CITY OF ALBUQUERQUE

April 30, 2019

RE: Cooperative Educational Services (CES)
10601 Research Rd. SE
Grading and Drainage Plan
Engineer's Stamp Date: 04/15/19
Hydrology File: M21D021

D1 STANDARD CURB OPENING
N.T.S.

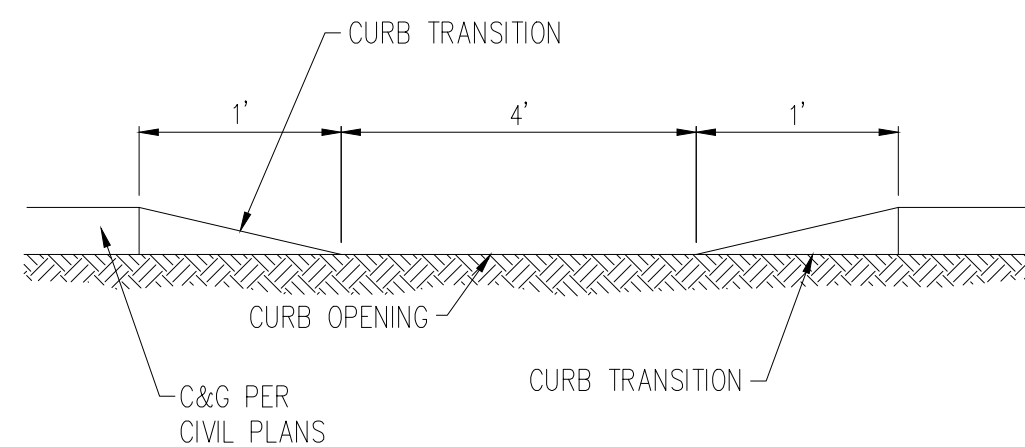
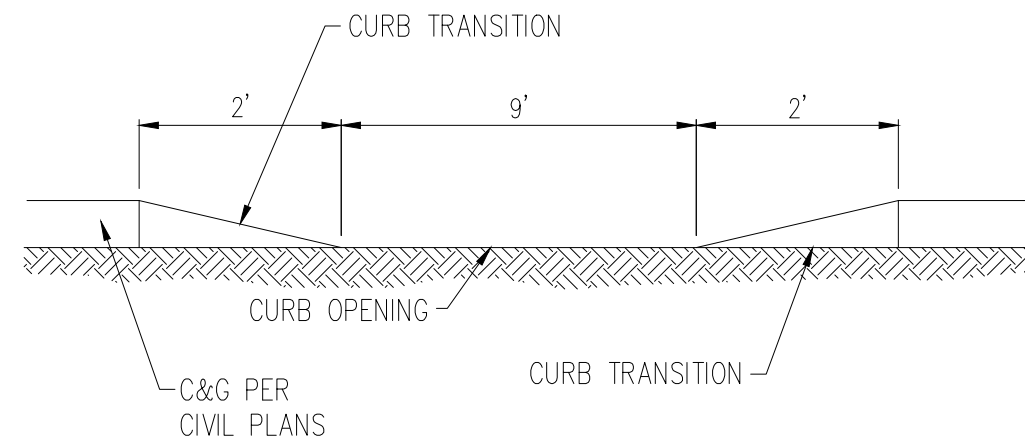
15. Sheet C302. Please use the broad crest weir equation in the DPM for the curb cuts. If you use a "C" value of 2.7, then the proposed 4 ft curb cuts can be reduced to a 2 ft curb cut and the 9 ft curb cut will be reduced to a 5 ft curb cut.

D5 A-A RETAINING WALL
NOT TO SCALE

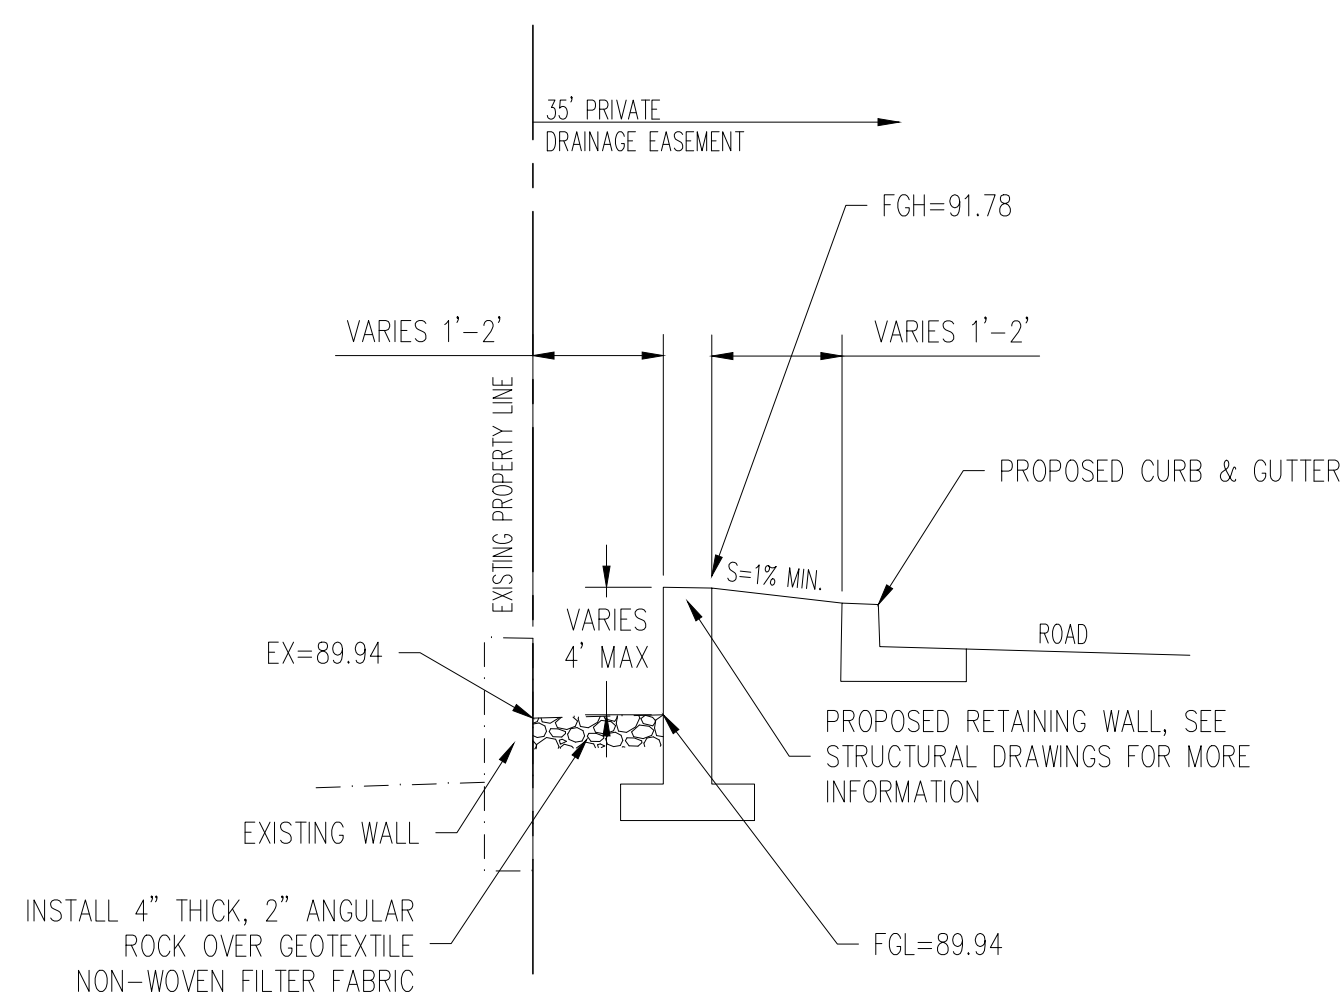
11. Sheet C300 & C302. Please label the site plan items on the adjacent property to the North as future development.
12. Sheet C300. In Section A-A, please add the 35' Public Drainage Easement.
